Blackpool Council - Development Management

Pre-application advice report

Reference: 20/0176

Proposal: Demolition of existing building and erection of six storey building to form a Cafe to ground floor and permanent flats to the upper floors.

DO NOT SCALE DIMENSIONS FROM DRAWING

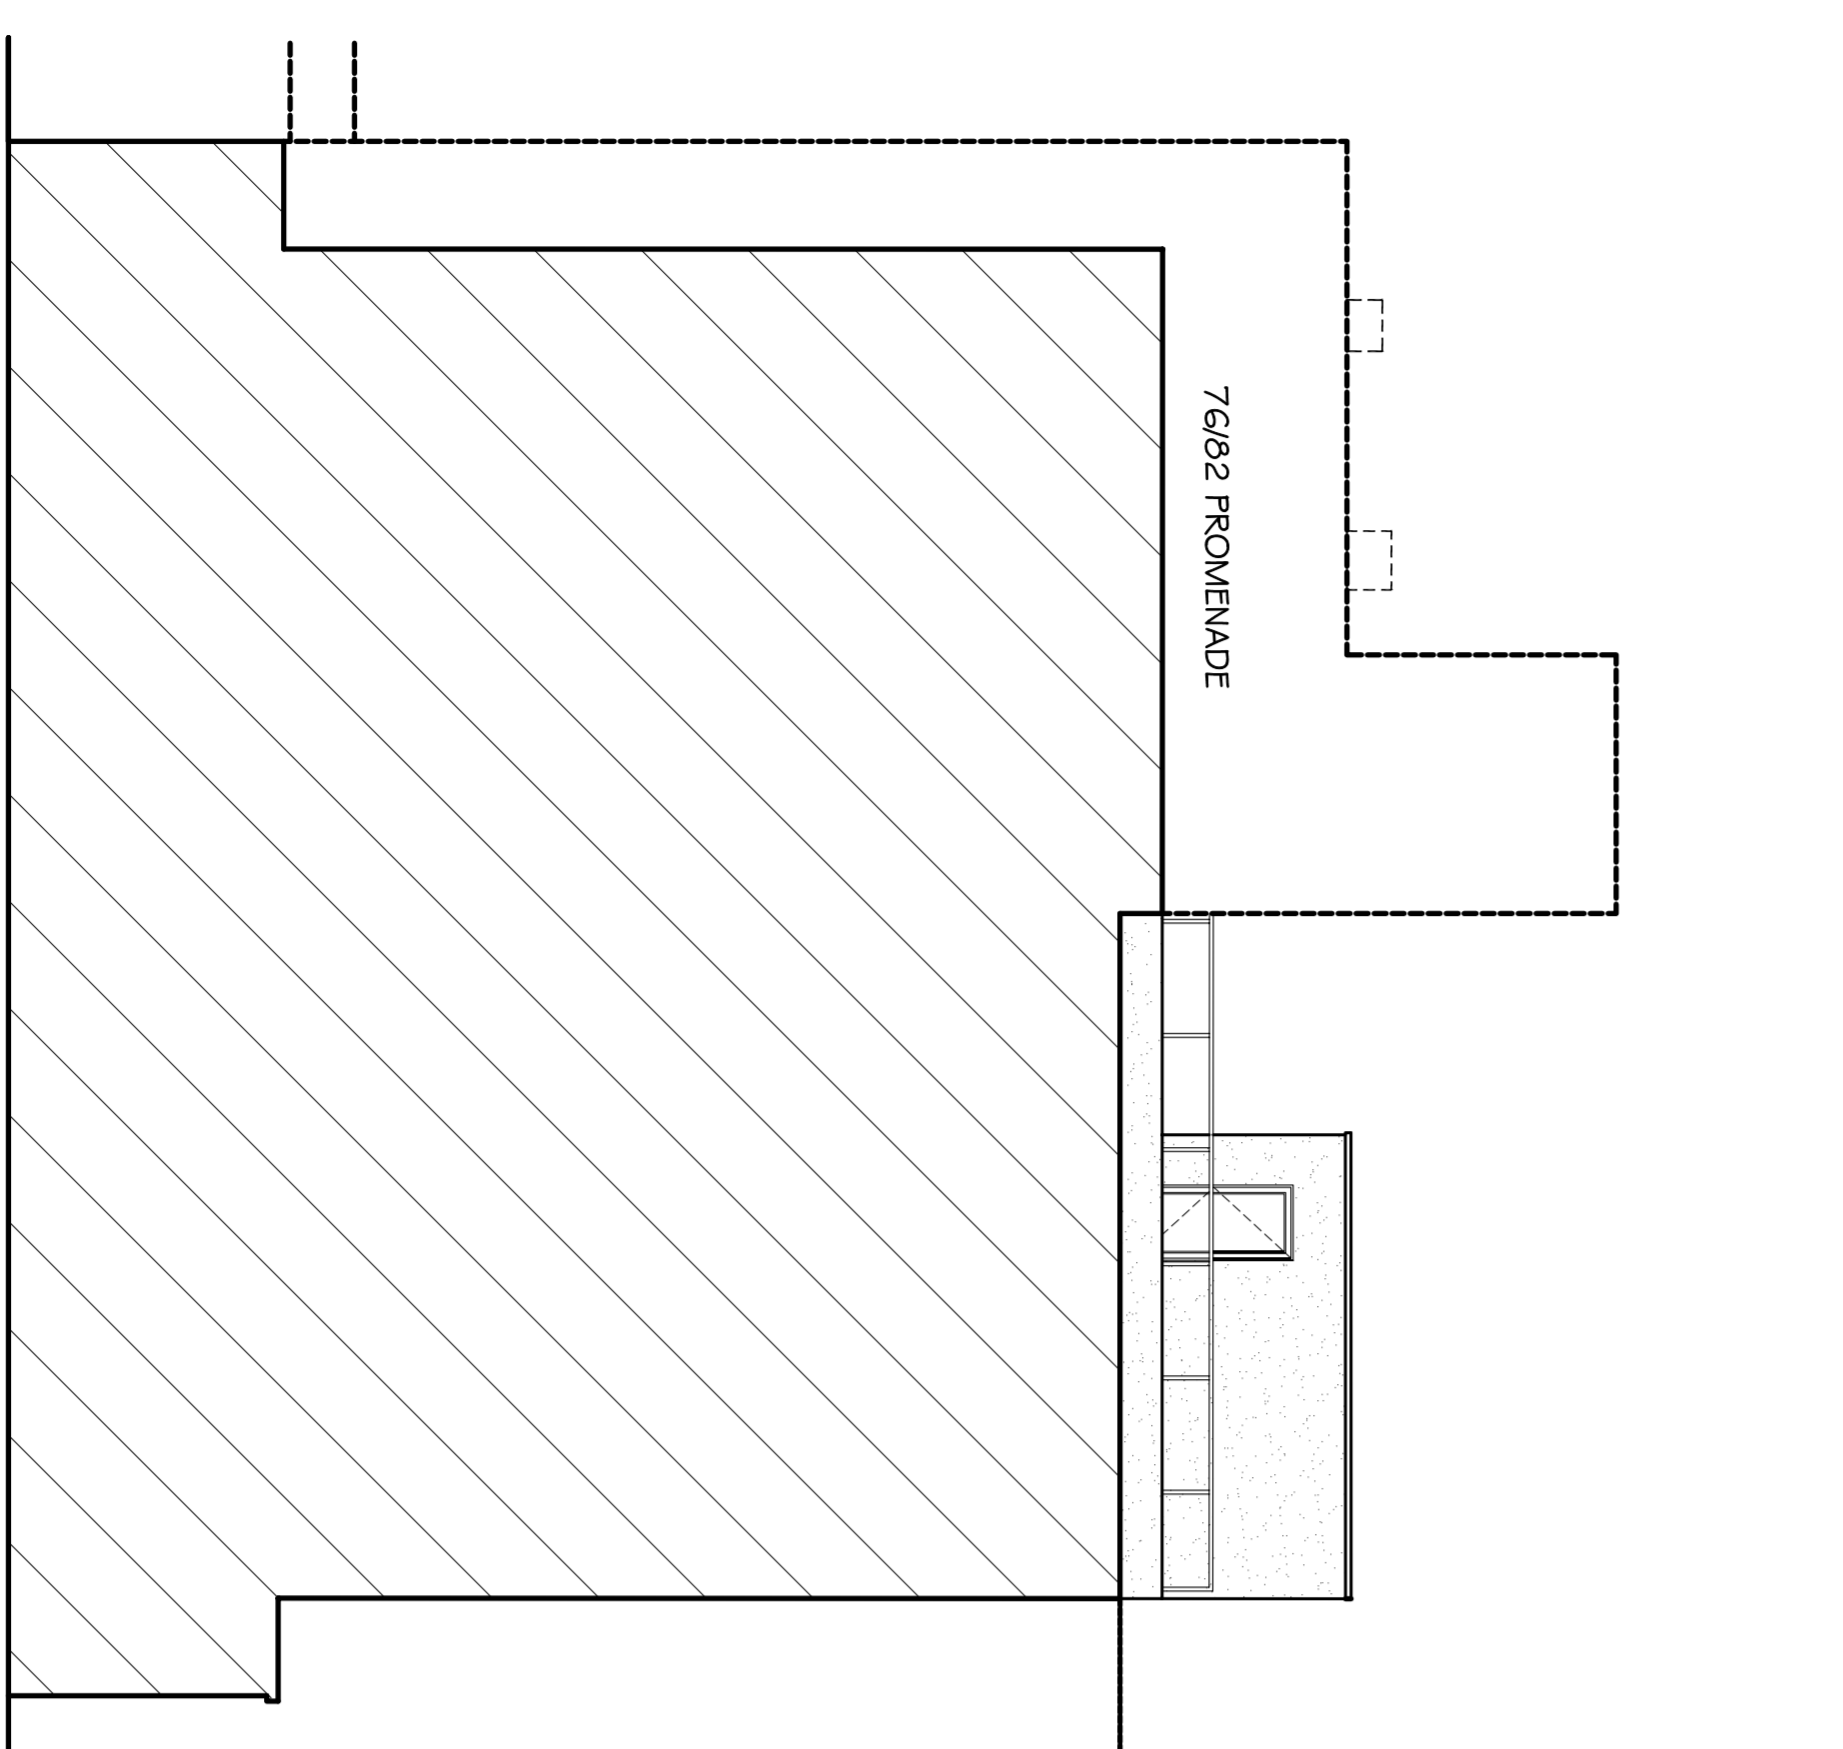
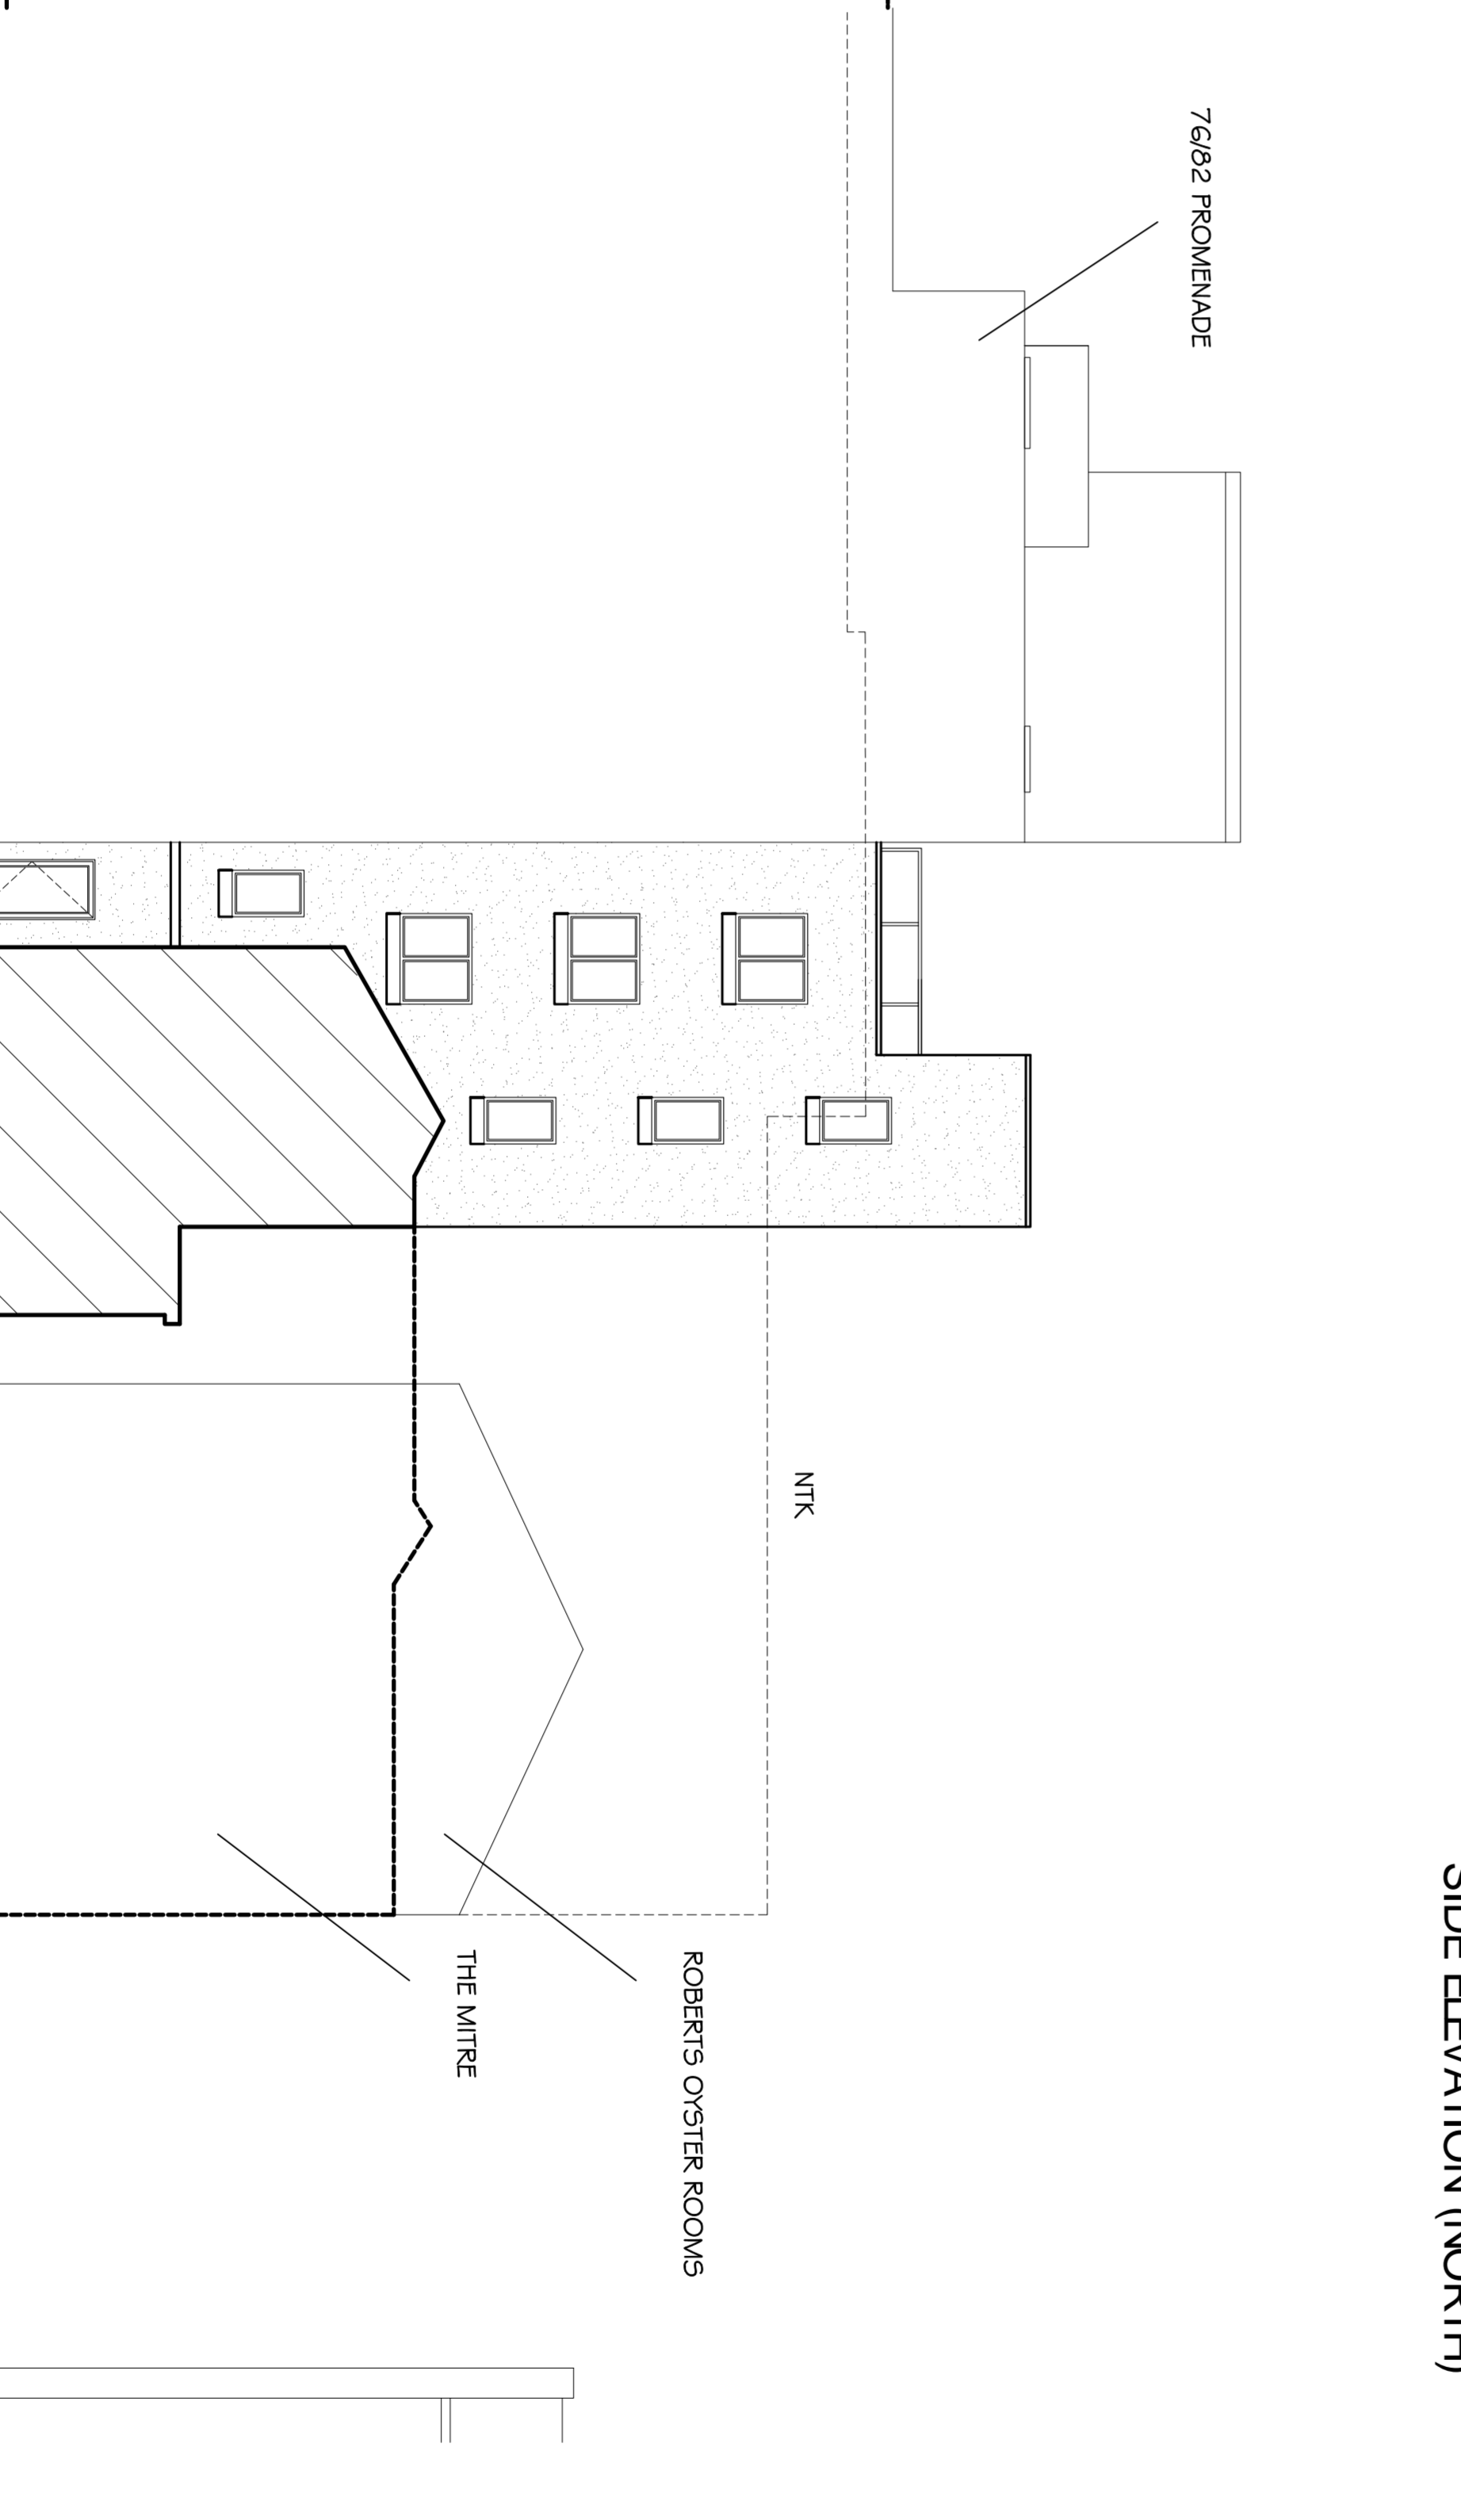
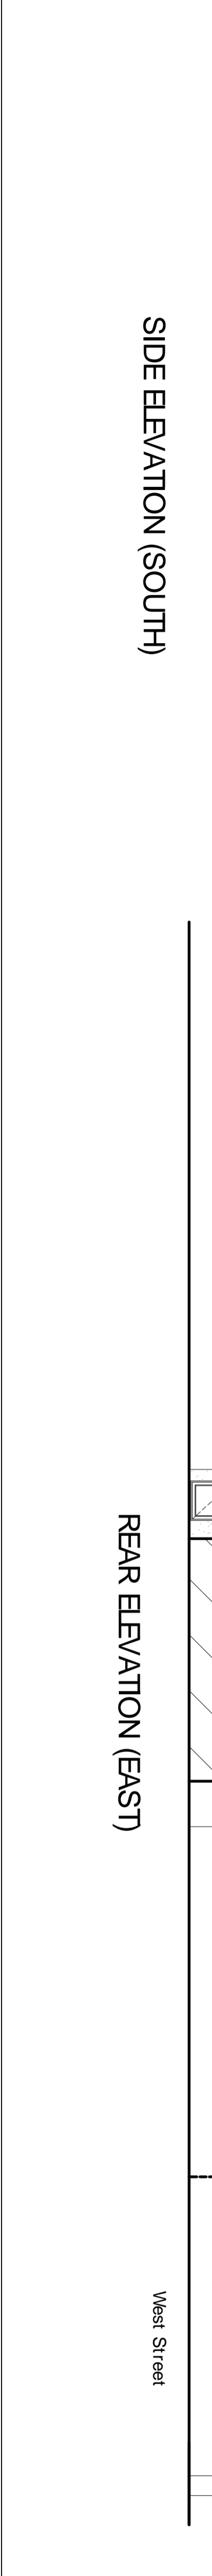
- 2.1 Erection of seven storey building (including a basement). To the side of the proposed building abutting Roberts Oyster Bar is a tiled lift shaft. There is a gap between the proposed building and Roberts Oyster Bar at upper floor levels with an attached single storey projection at ground floor level which contains the entrance to the flats. The building abuts the Superbowl building. The building projects forward of the Oyster Rooms but not forward of the Superbowl building. The bays on the Superbowl frontage are not accurately reflected in the north elevation, neither is the canopy. Also, the canopy on the Oyster Rooms projects much further forward than the Superbowl building, this relationship is not shown accurately on the elevational drawings.

- 2.2 The building proposes a café and toilets on the ground floor, with kitchen, cellar store, bottle and bin store and plant room in the basement. The upper floors comprise a two bedroomed permanent flat on each floor i.e. five flats in total, each with a Promenade facing balcony and with an open roof terrace above. The south side elevation does not correlate with the north elevation and the east elevation appears to show the gap between the proposed site and the Oyster Bar closed up.

to the adjoining Superbowl building, however the roof terrace would require a larger wind break than shown and that in itself would have a visual/adverse impact on the height and scale of the building. Any new building should step down in height from the Superbowl building to the surrounding, locally listed buildings to better fit within the context. Detailed approval of facing materials would be dealt with via an appropriate condition.

5.3.2 The main front elevation of the proposed building lies behind the Superbowl frontage, as do the balconies. The three storey height Roberts Oyster Bar projects forward to the same level as the main front elevation of the Superbowl. Roberts Oyster bar has a single storey canopy projecting further still. In terms of the position of the proposed building within the Promenade streetscene insufficient clarity has been provided to ensure that it would be acceptable.

5.3.3 The design takes its cues from the former Savoy café to the right. However, as stated, the height needs to be reduced so it steps up more gradually from Roberts Oyster Rooms by losing the top floor (so the roof terrace is lower down). It also makes permanent the current poor design which has brought forward the building line at street level. The proposed stairs to the upper floors from this area would mean the small infill next door to Roberts Oyster Rooms would become a permanent fixture, not only diminishing its individual character as one of the oldest buildings on the Promenade but also bringing forward the upper floors so they cover more of the side elevation of the Oyster Rooms. It would obscure some of the existing features of the building principally the name sign on the side elevation, which is part of the fabric of the building. Whilst the Oyster Bar is not statutorily listed it is nevertheless of local historic interest and the obscuring of the building detailing is not acceptable on this Locally Listed Building within the Conservation Area.

5.3.4 I would suggest that the infill/lobby for the stairs is removed to open up the gap between the Oyster Rooms and the new building. The building line for the whole building should be set back (so the café is flush with the upper floors and should not project forward of the adjacent Oyster Rooms) and the entrance for the flats should also be set back. The vents should be set further back within the site. The design would need to reflect the locality (i.e. art deco like the remainder of this block with appropriate materials). The ground floor infill detracts from the setting of the Oyster Rooms. This would be an opportunity to enhance it whilst mitigating the loss of a building which has some architectural merit. If the scheme is eventually approved then it should be recorded by the appropriate RIBA standard before demolition.
